**RE: BP#2016-01319 167 -169 Newbury Street - Preliminary plan review (Foundation only)**

**Subject:** Re: BP#2016-01319 167 -169 Newbury Street - Preliminary plan review (Foundation only)

1/16" = 1'-0"

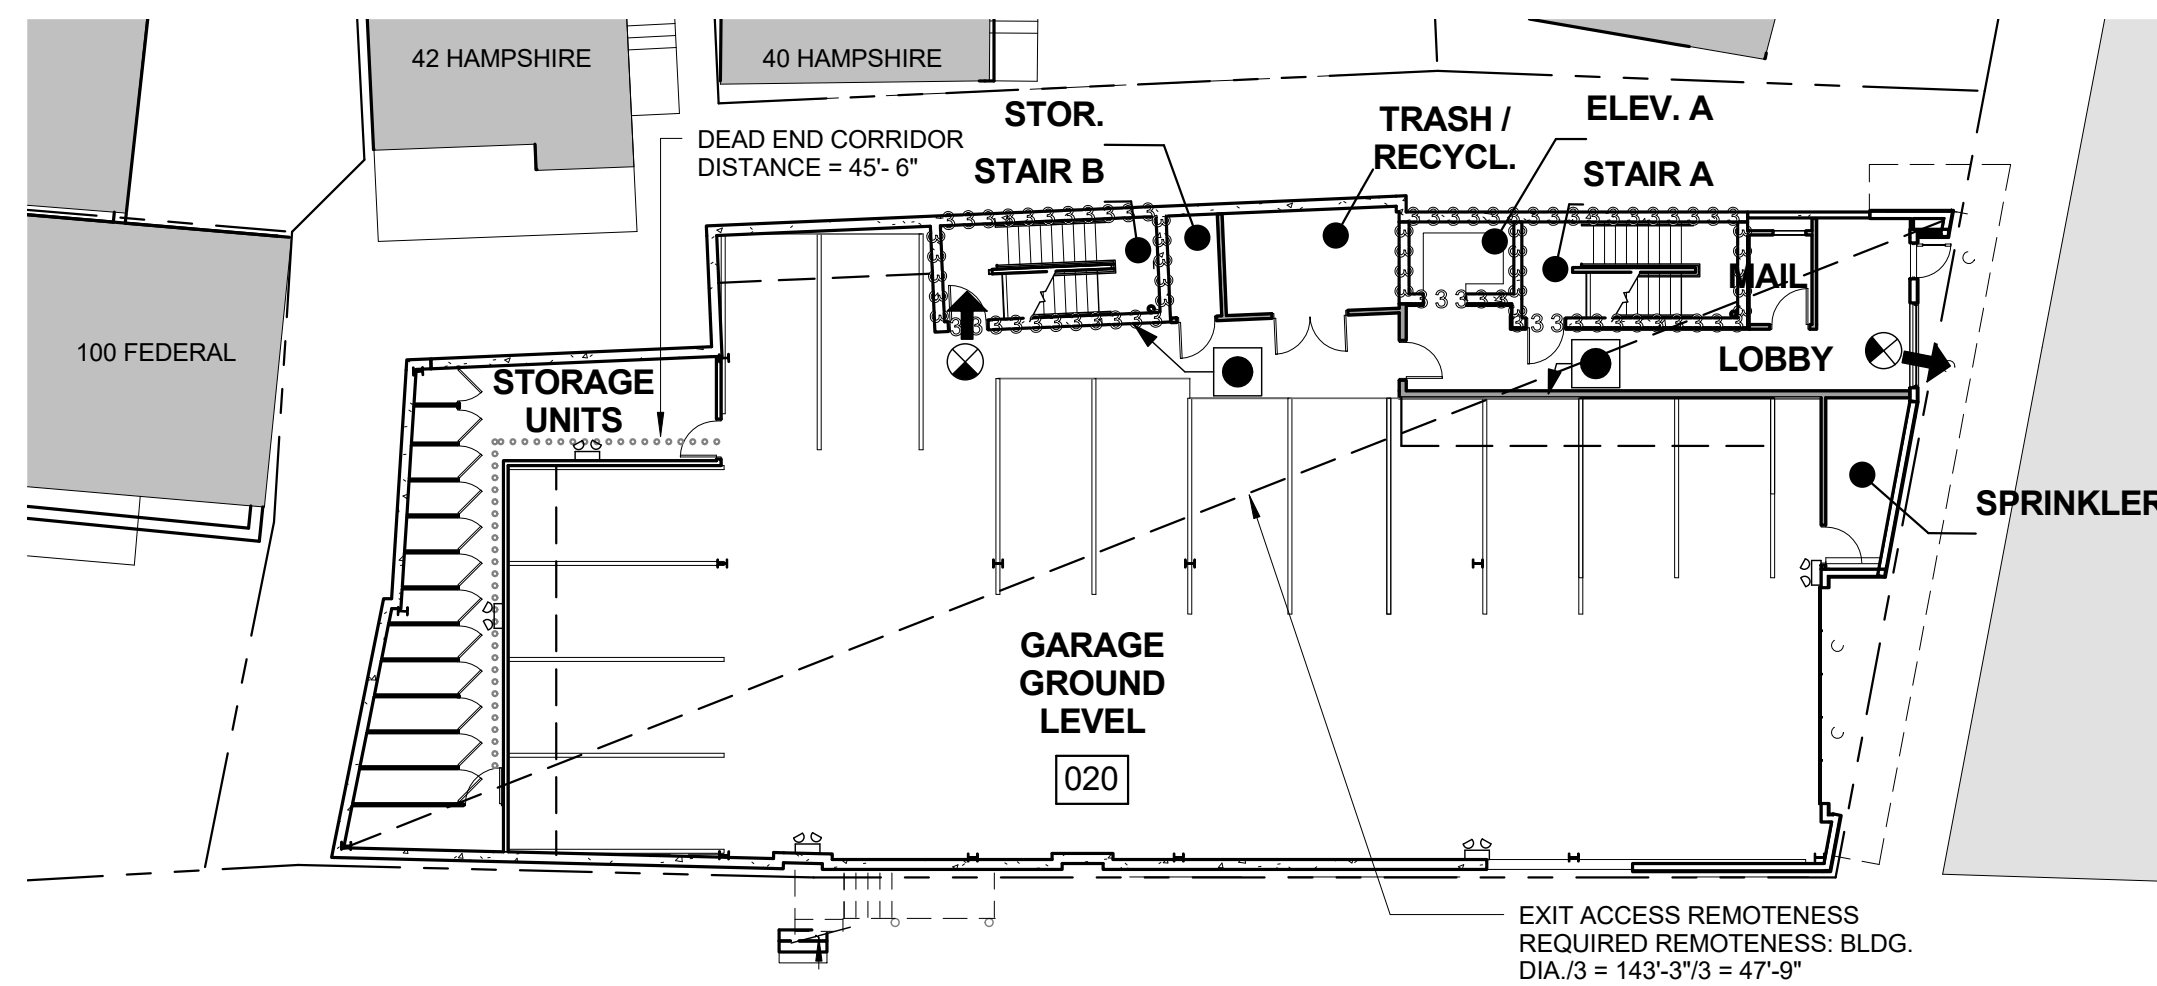
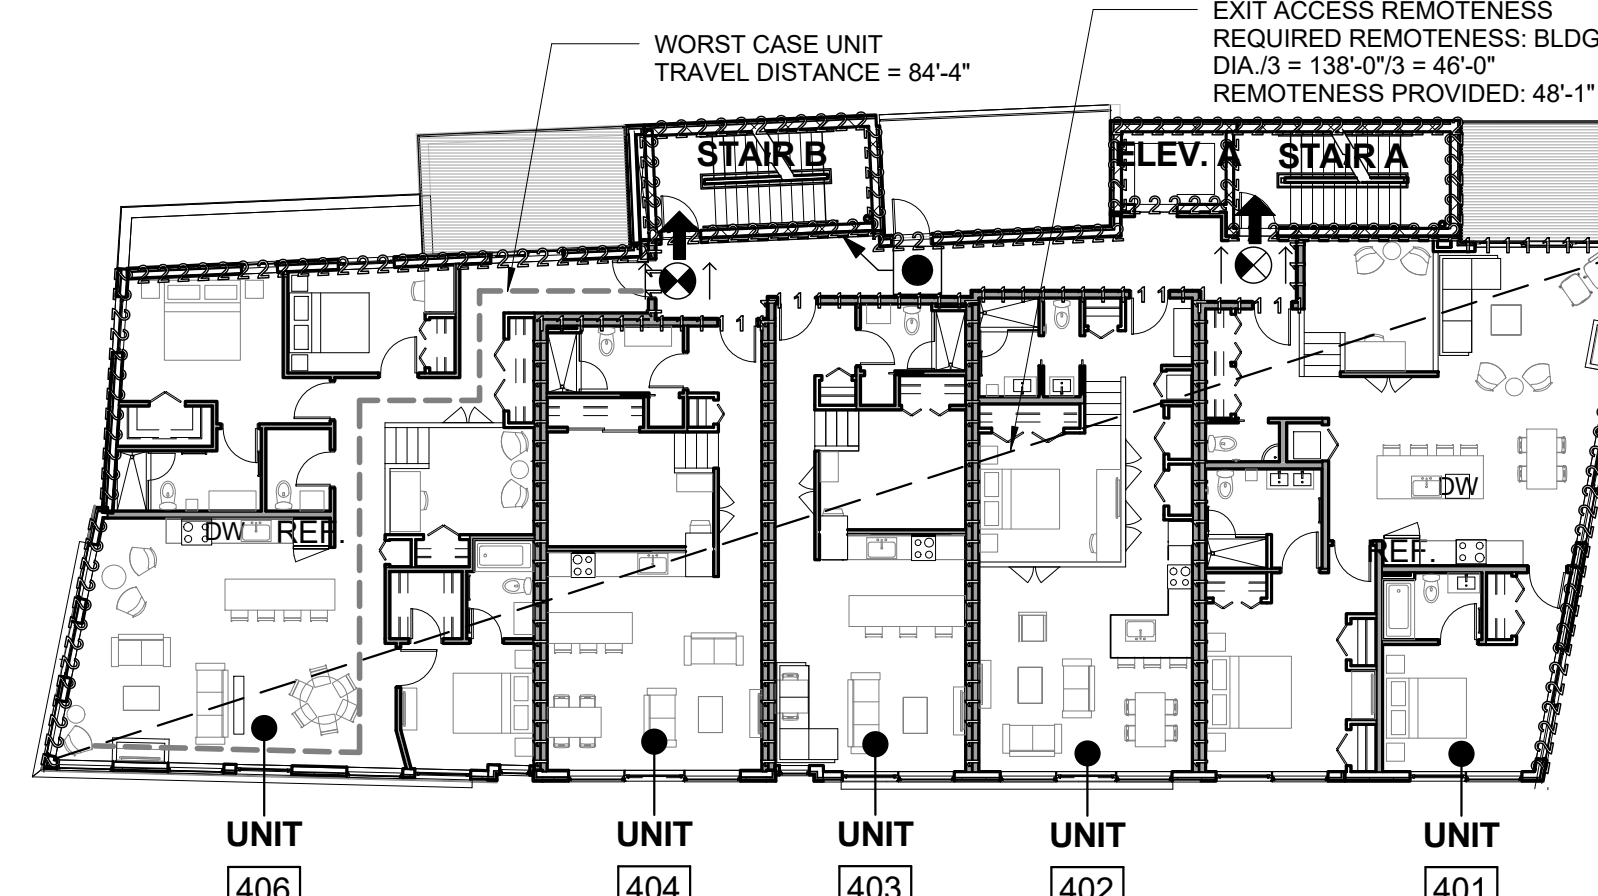
- All plans should be stamped including the code analysis and life safety plan. **The attached code analysis and life safety plan are stamped. I bubbled any changes since the last drawings I sent you.**
- Provide occupant load calculations in the code analysis. **The occupant loads are located in section 1005. I pulled out the fitness room as a separate occupancy (I clouded this section so it is easy to find)**
- The fitness center on the first floor looks to be greater than 10% of the floor area. Clarify how you justified this being an accessory occupancy. **You are right that the floor area is greater than 10%. I pulled the fitness room out of accessory occupancy and created it as separated use. Per table 508.4 we don't need any separation between the garage S-2 and fitness room A-3.**
